**RFI**

**RFI #:** 161  
**Date:** 6/25/2012  
**Job:** EB-02 Keller Springs Lofts  
**Phone:** 877-777-5115

**Subject:** Electrical Outlets Moved for Code

**Subject:** Electrical Issues with Units, Fixtures Missing

**E-2.11**

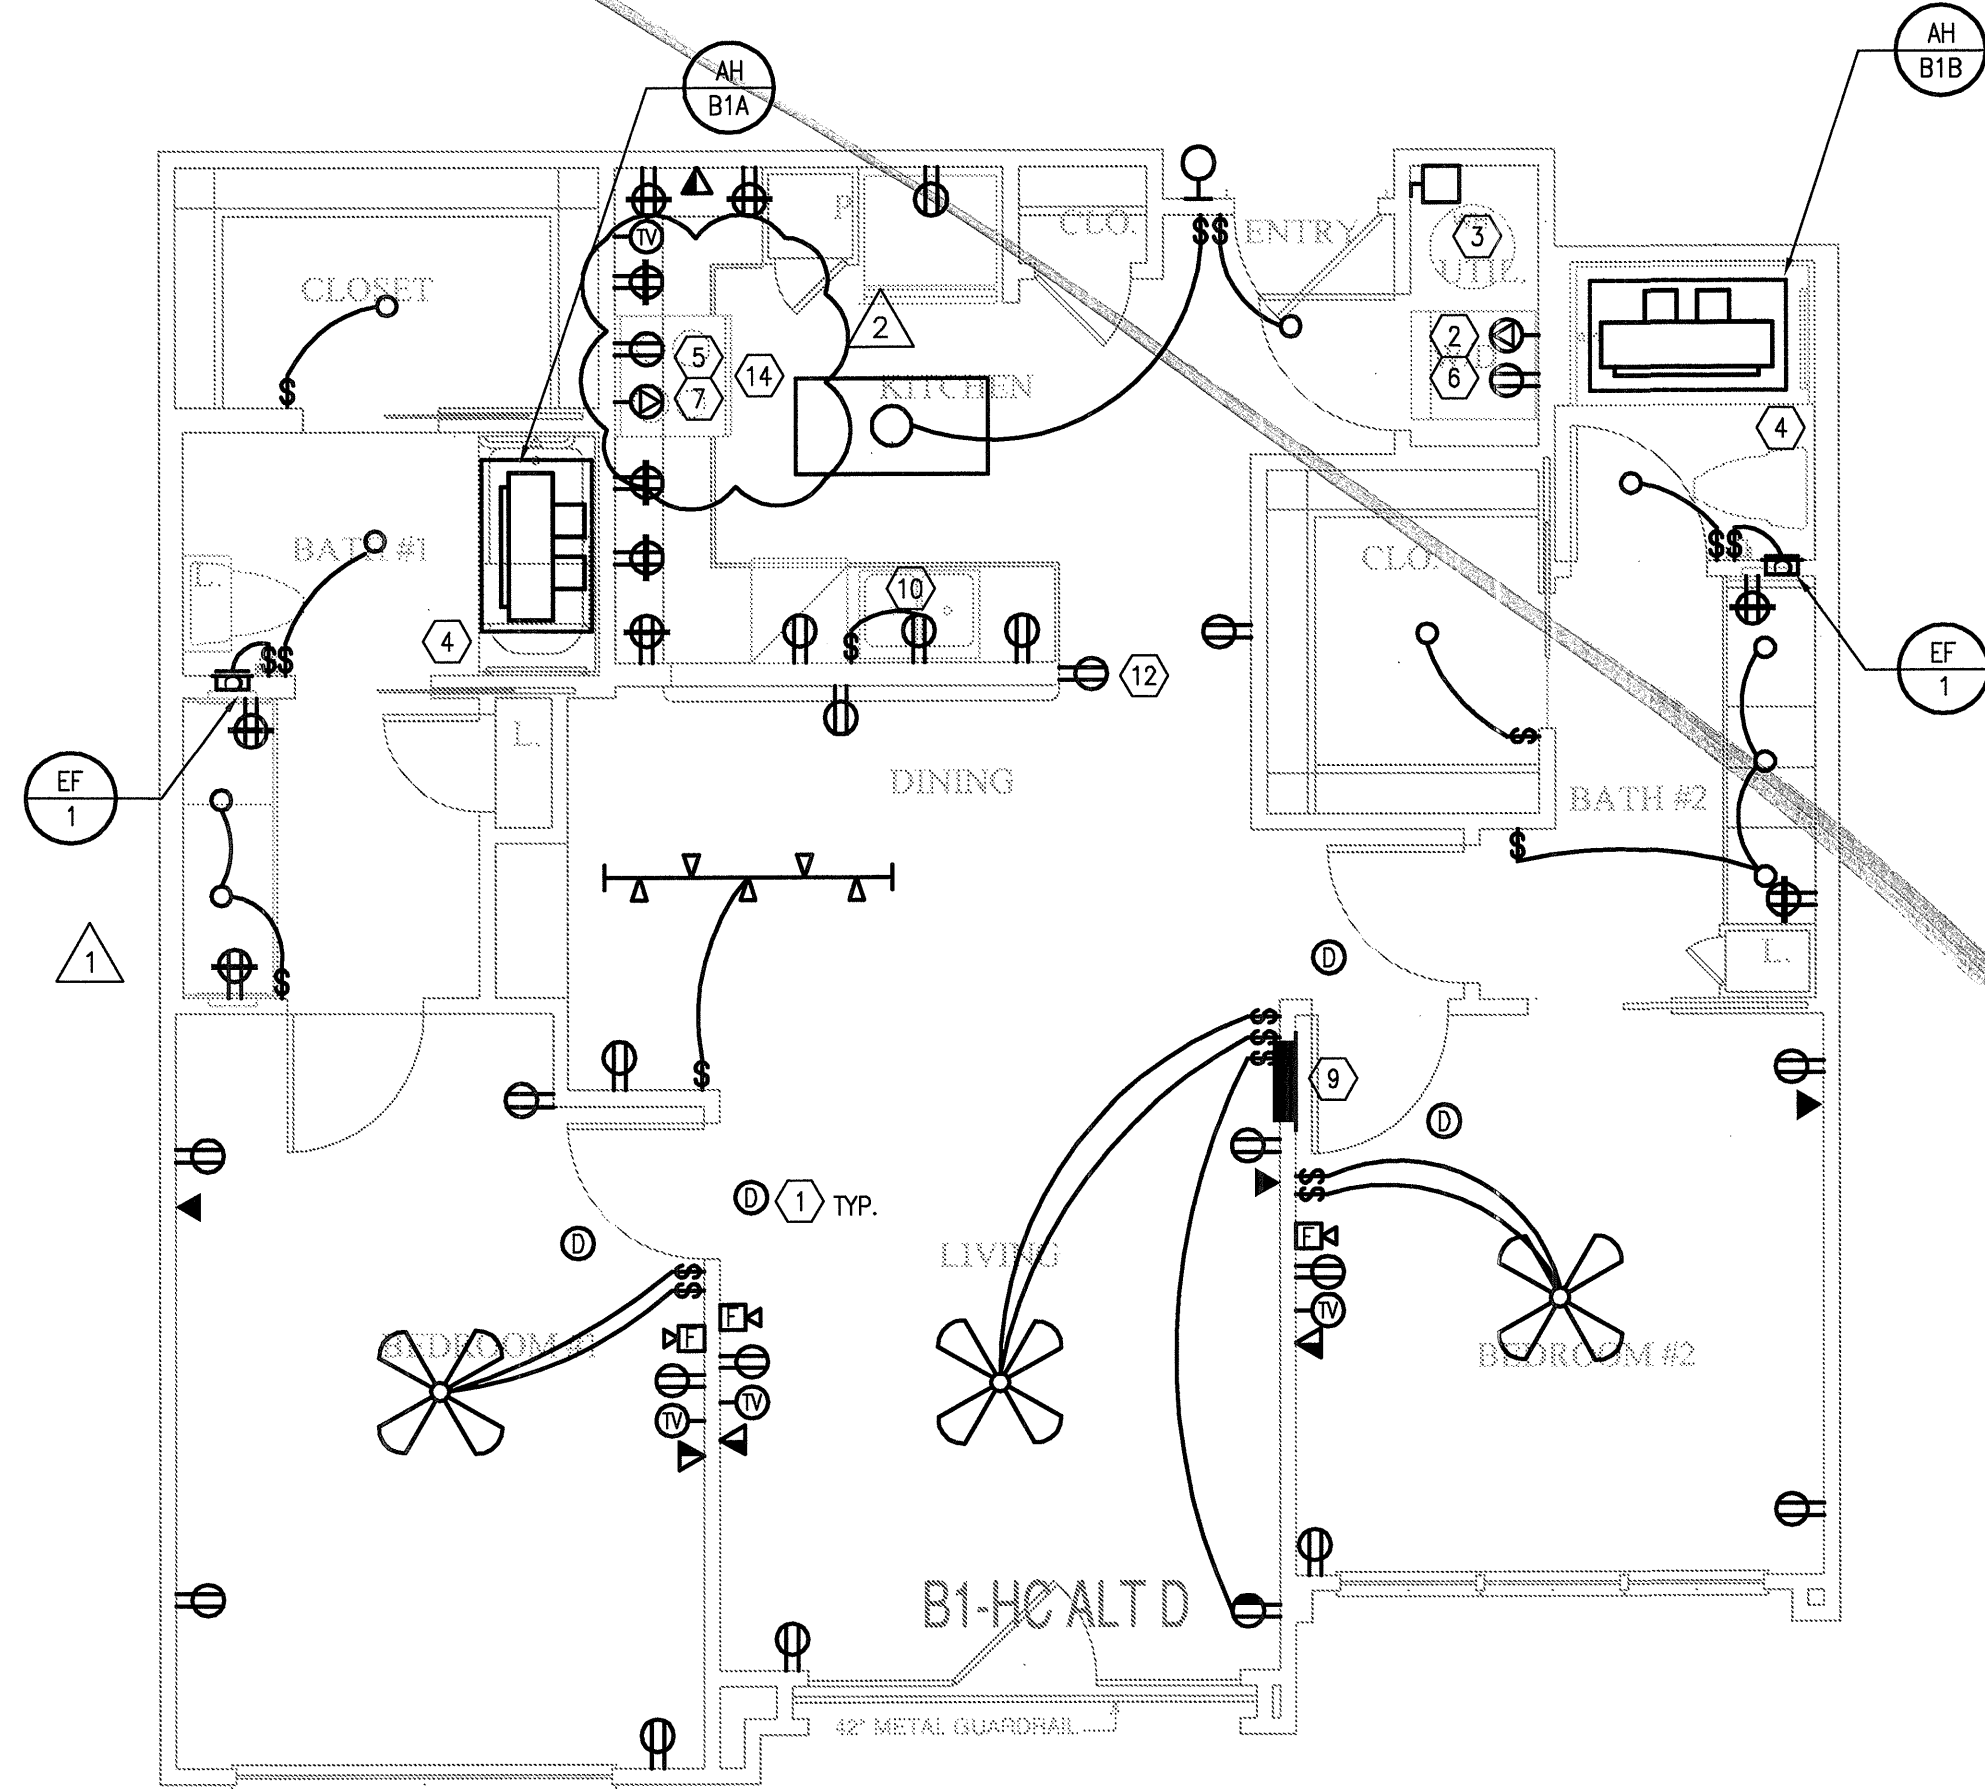
**Request:** **Date Required: 5/23/2012**  
 1. Patio receptacles will either not fit or there will probably be too much framing for the rough in boxes to fit in the following units: A1, A3 ALT-D, A3 ALT-E, A4, B1, B1-L, B1-K, B2C-ALT1 and A1-HC.  
 2. None of the pendant lights are shown on drawings.  
 3. Switch for bath exhaust fan in A2-SP and A1-HC are not shown.  
 4. Switch for living room ceiling fan light is not shown for A2 and A3 units.  
 5. Living room switched outlet is not shown in the E1, A2SP and B3 units.

**Response:**  
 1. Per NEC 210.52, a receptacle must be placed within the perimeter of the balcony or deck. If space is not available to mount recessed, a surface mount receptacle may be used.  
 2. Pendant lights shall be shown on the upcoming clubhouse revisions issue.  
 3. Locate bath exhaust fan for the A1-HC unit next to the three way switch in the bathroom on the common wall with the kitchen. For the A2-SP unit locate the bath exhaust switch next to the switch for the light over the toilet.  
 4. locate switch for ceiling fan light next to switch for ceiling fan.  
 5. All units should have switched light in the ceiling fan, therefore the switched receptacle is not required, unless owner's desire is to keep it.
